Application no: **3/2021/0445**

Address: **The Brows Farm Brows Barn Higher Road Longridge Preston PR3 2YX**

Proposal: **Proposed change of use from office hub to dwelling.**

The Local Highway Authority have viewed the plans and highway related documents and have the following comments to make:

Drawing Title
PROPOSED SITE PLAN

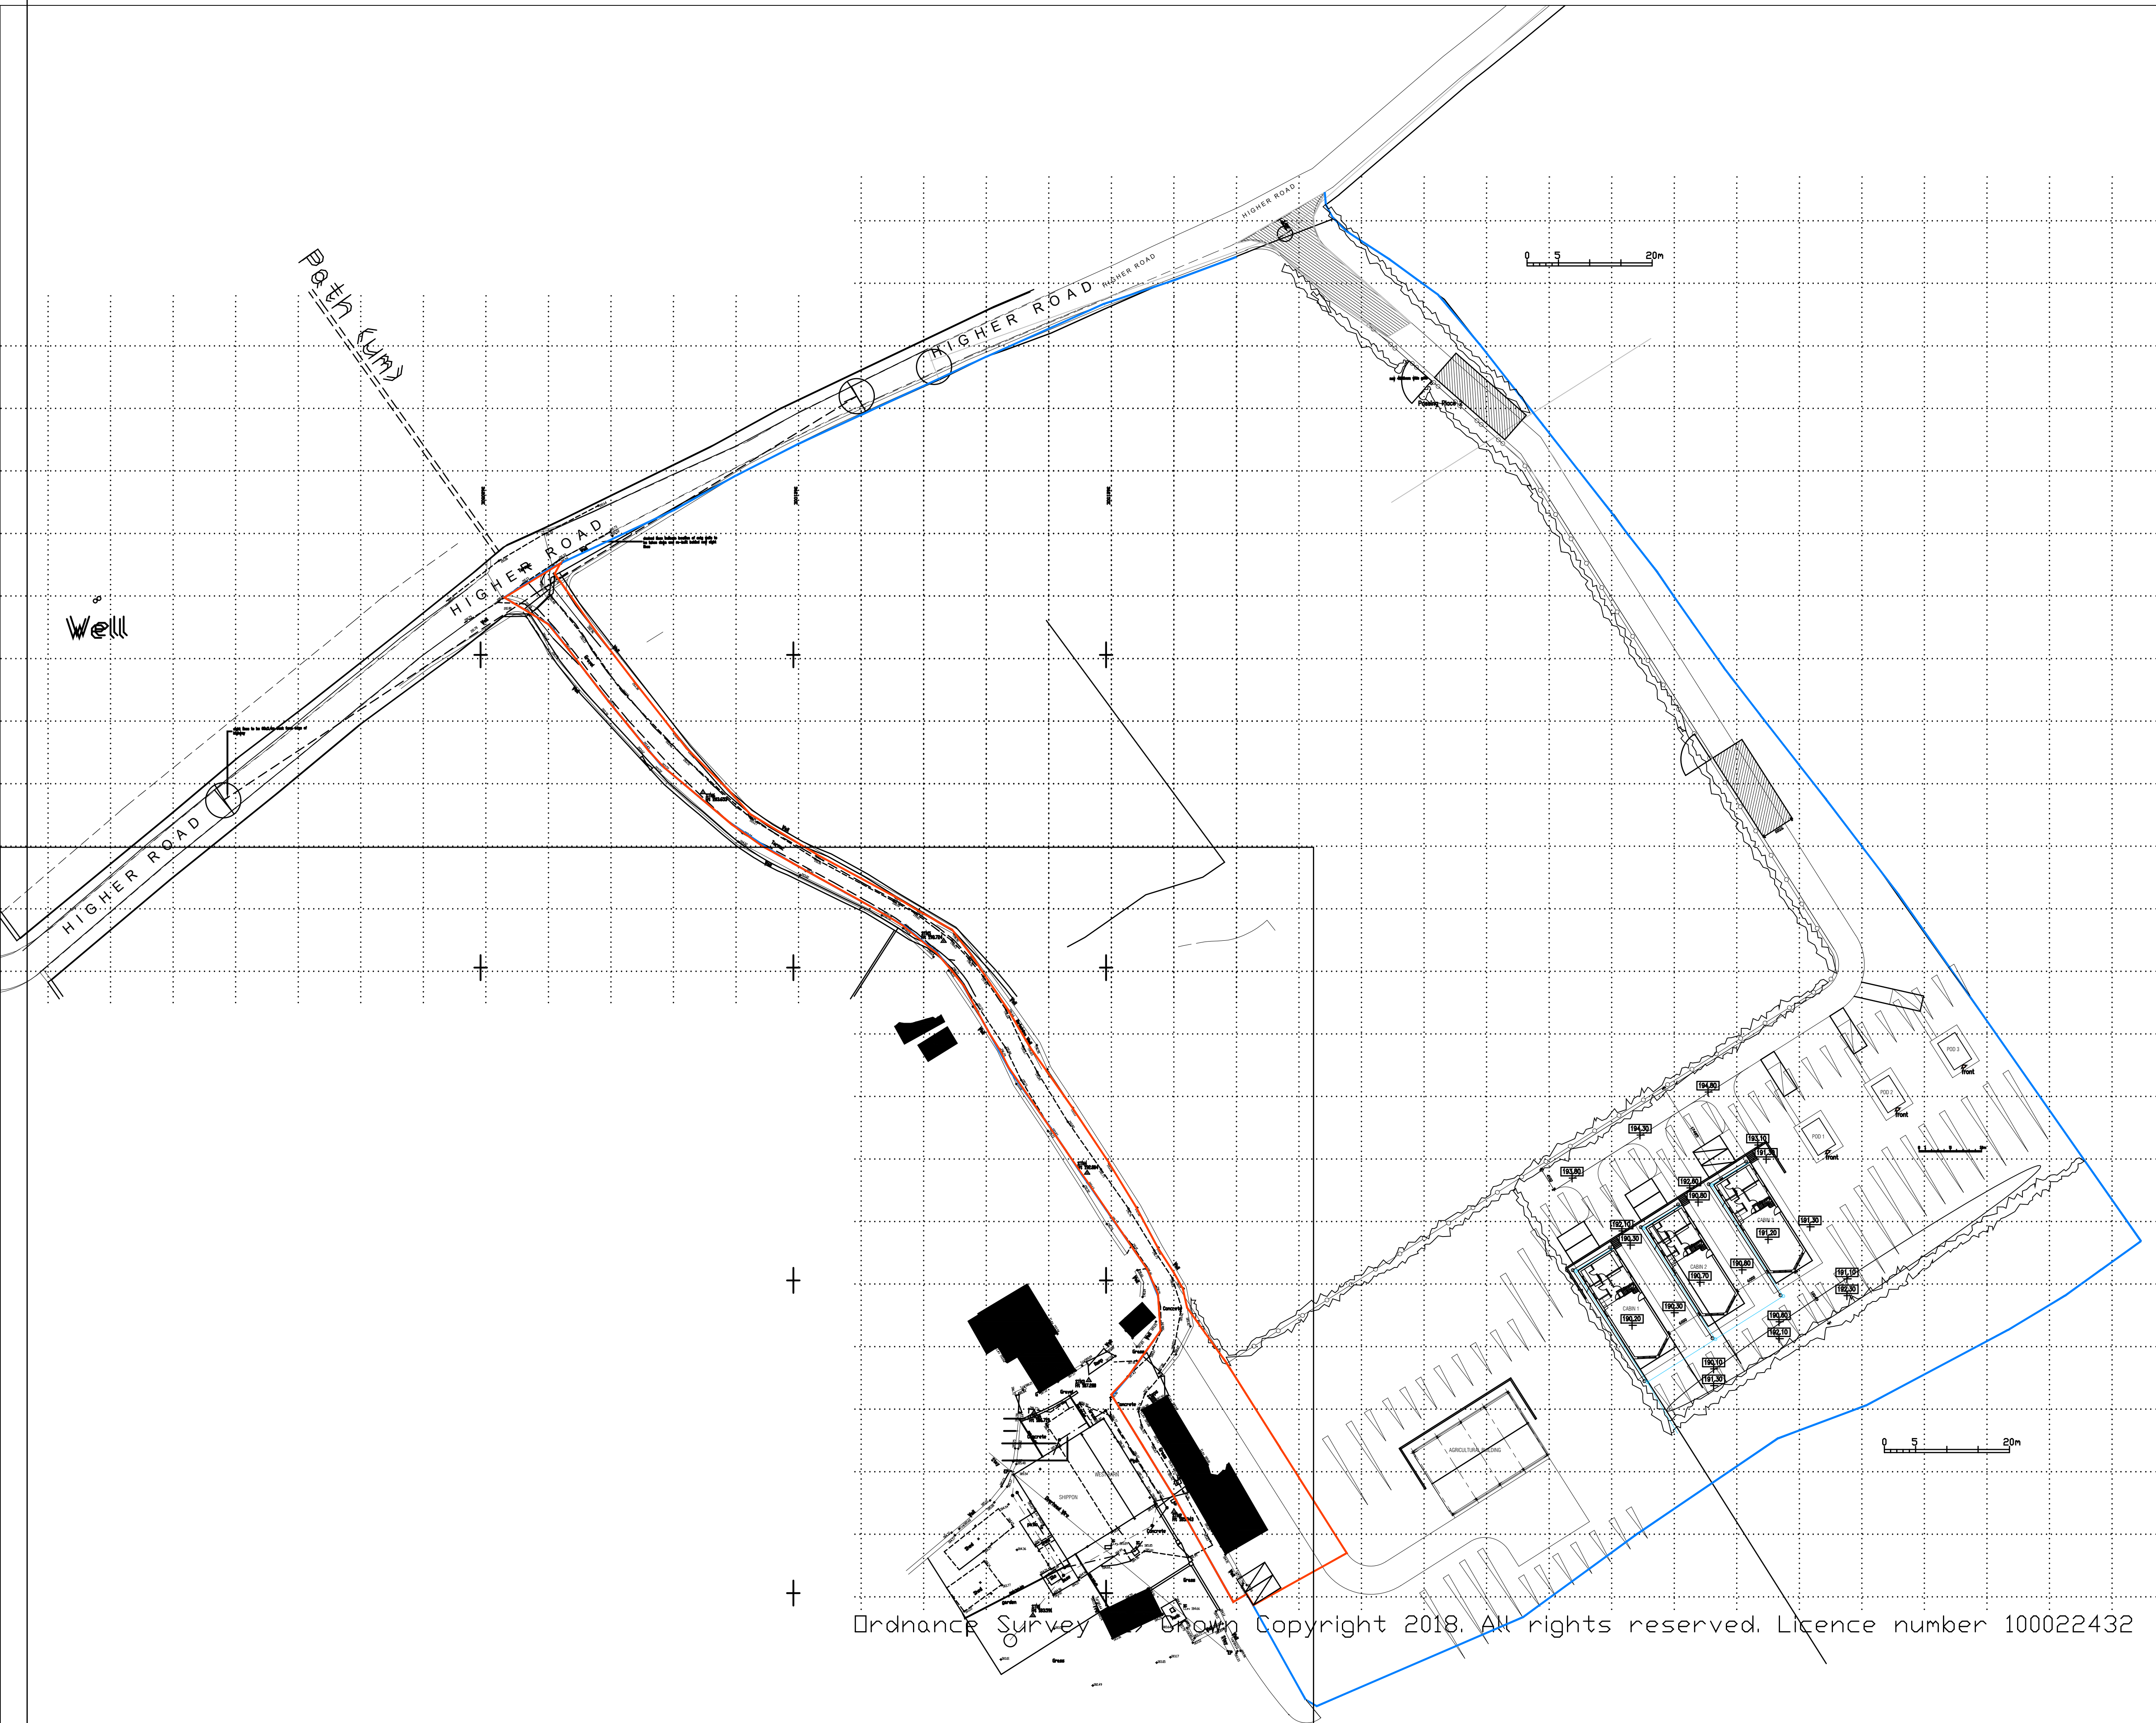
The LHA have reviewed ALH drawing number 04B titled "Proposed Site Plan" which shows the site will provide 2 car parking spaces for the 2-bed dwelling. This complies with the guidance contained in the Joint Lancashire Structure Plan and therefore the LHA have no objection to the proposal.

1. The development hereby permitted shall not be occupied until such time as the parking and turning facilities have been implemented in accordance with ALH drawing number 04B. Thereafter the onsite parking provision shall be so maintained in perpetuity.
